please ask for: Rachel Horton
direct line: 01200 414501
email: Rachel.Horton@ribblevalley.gov.uk
my ref: RV/2013/ENQ/00109
your ref: cn/jb/13:109:001
date: 14th August 2013

REQUEST FOR PRE-APPLICATION ADVICE RELATING TO PROPOSED REPLACEMENT DWELLING AT 72 MELLOR BROW, MELLOR.

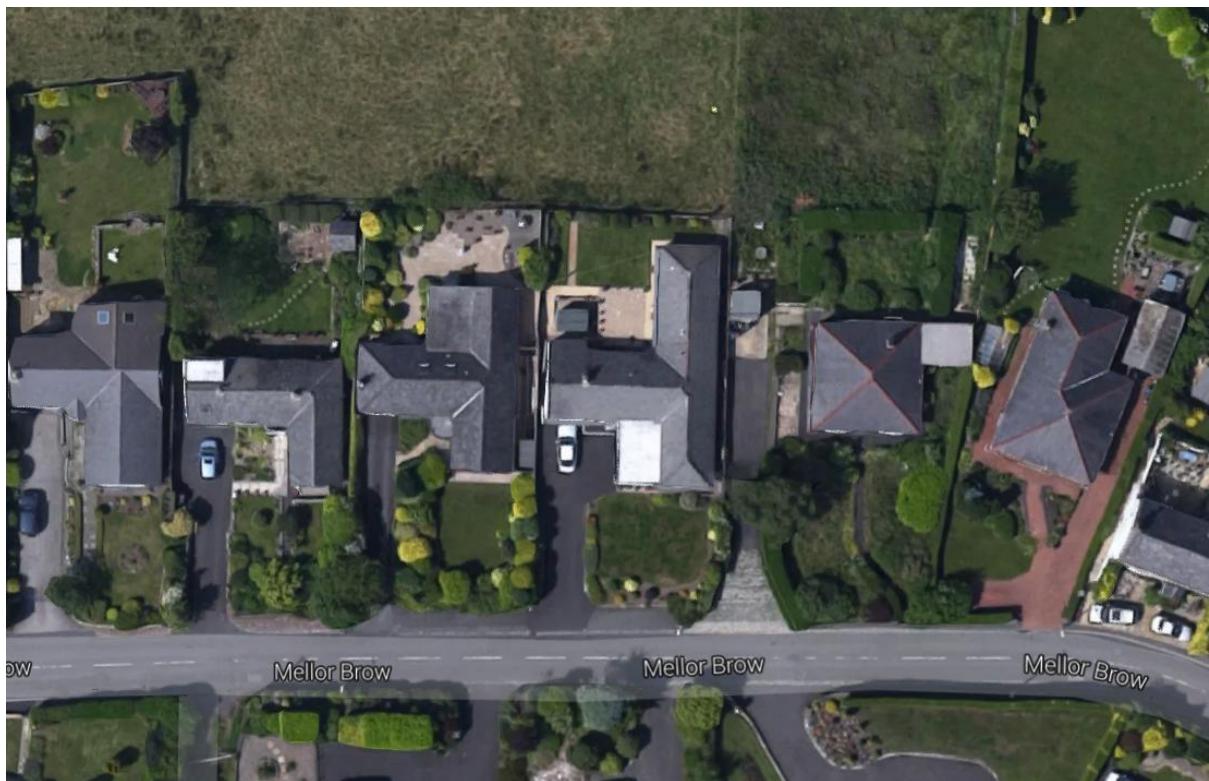
Policy H14 of the DWLP states that excessive increase in the size of the property will not be permitted. As a general guide, the original volume of the dwelling should not be increased by more than 70 cubic metres or 15% (whichever is greater). It is clear that the proposed footprint of the building and its overall size and massing is to be significantly larger than the existing bungalow. Due to the topography of the area, properties to this row currently step down when travelling on Mellor Brow in a westerly direction. The eastern side of the property at first floor level steps down from that of 70 Mellor Brow to the east but then steps up to a height which is significantly higher than the ridge of 74 Mellor Brow to the west. I consider that this design coupled with the horizontal emphasis of the building, cantilevering/projection of the first floor element and flat roof would result in a highly prominent, discordant and disproportionate building within the street scene, which does not reflect in design terms the more modestly sized properties to the east and west, contrary to the design principles of the above policies. You mentioned that the double height feature of the property could be reduced and that a mix of render and cladding would reflect the local vernacular. However I do not consider that these amendments/additions to the property will satisfy my strong concerns regarding the visual impact of the dwelling that is highly prominent on approach in a westerly direction within the public realm, as confirmed by my site visit.

I have serious concern that due to the topography of the site the scale and massing of the two-storey dwelling will have an overbearing and oppressive impact particularly upon the residents of No. 74 Mellor Brow to the west. The dwelling would tower above

the ridge height of No. 74 Mellor Brow, which is currently set-down from No. 72 Mellor Brow. In addition, windows at first floor level to the western side elevation serving a bedroom and dressing area due to their height will have clear and unobstructed views of the whole of the rear elevation and garden area of No. 74 Mellor Brow. In addition, and again due to the height of the property I also have concern regarding loss of privacy to the residents of No. 70 Mellor Brow to the east as a result of overlooking from the bedroom window to the rear of the property at first floor level to the eastern elevation.
